Submission on the proposed West Culburra Mixed Use Concept Plan-SSD3846

WEST CULBURRA MIXED USE CONCEPT PLAN

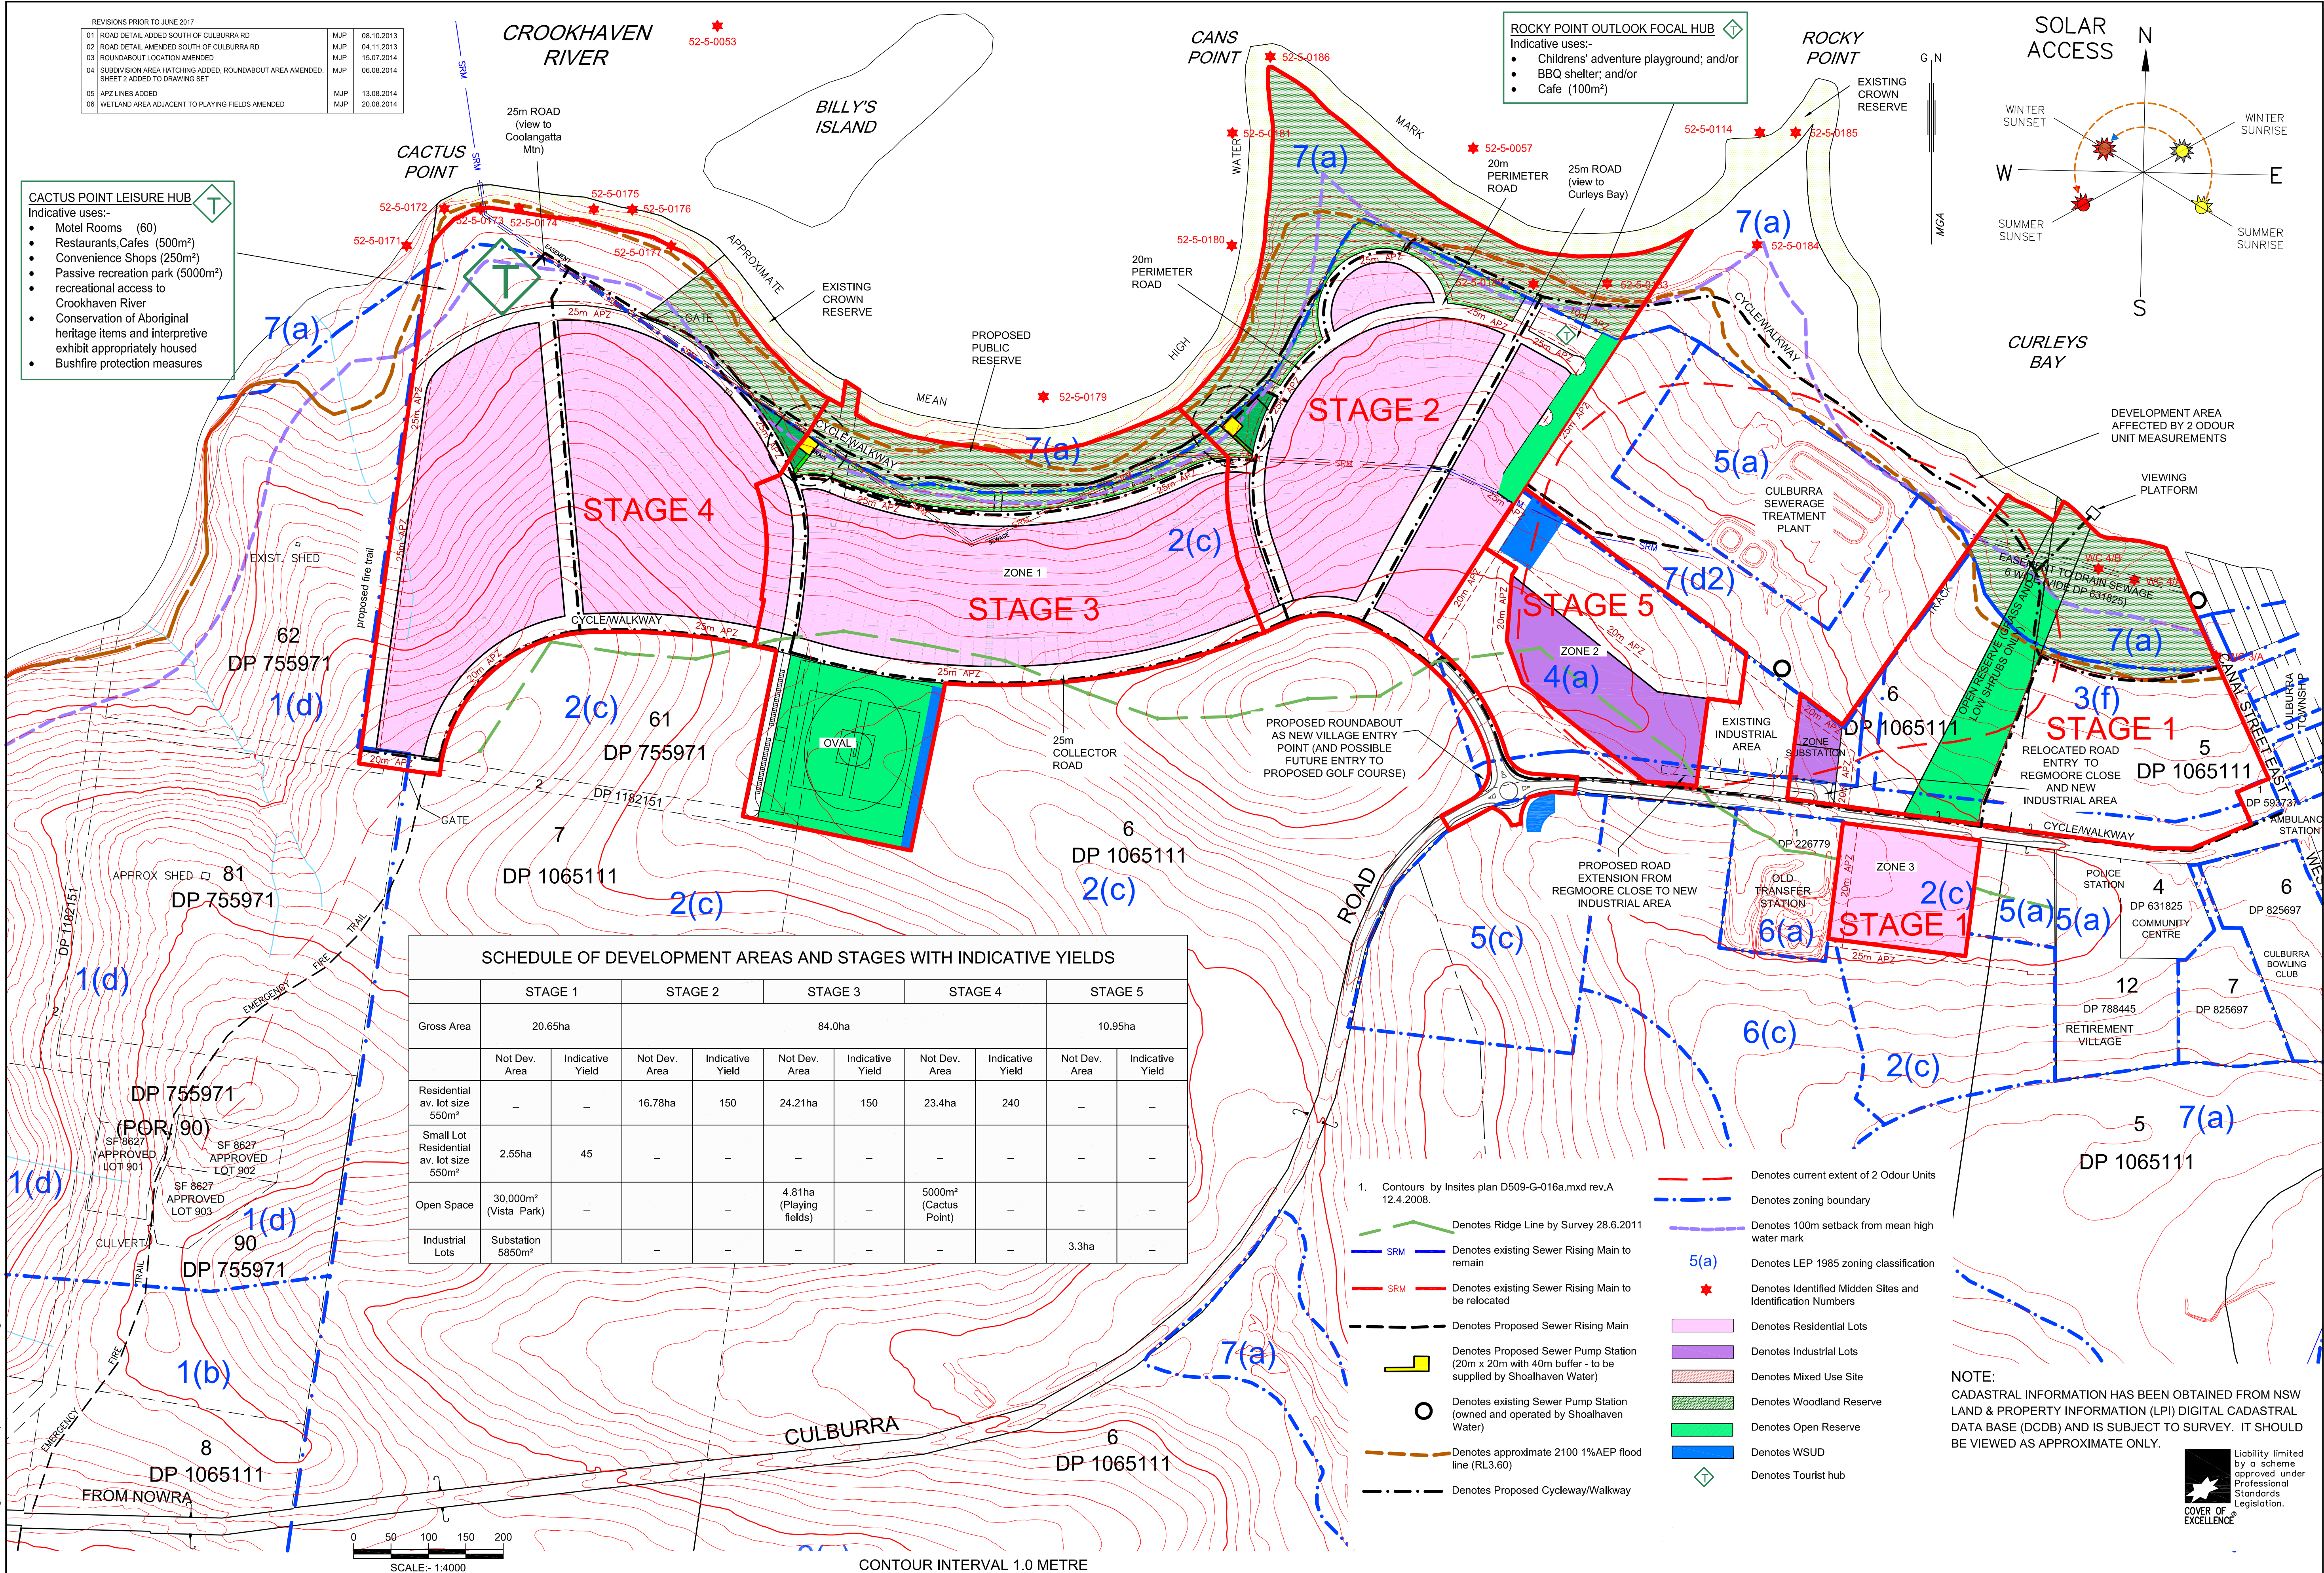
- Bushfire Hazard & Emergency Access
 - Last year’s devastating bushfires bring into sharp focus the risk of the proposed residential area almost totally surrounded by eucalypt forest with a single major access road. A single access road might prove inadequate during an emergency evacuation

- Major Site Constraint- existing Sewage Treatment Works
 - Siting the major residential area immediately adjacent and to the west of the existing treatment plant is highly undesirable, particularly in the summer with prevailing easterly seabreezes. This is exacerbated by the proposed adjacent industrial area with its associated noise and odour.

- Placemaking
 - The development should be best practice and create a strong positive identity ,however the disconnected nature of the residential, lack of local internal open space and integrated cycling/walking networks does not appear to facilitate a healthy ,connected community.
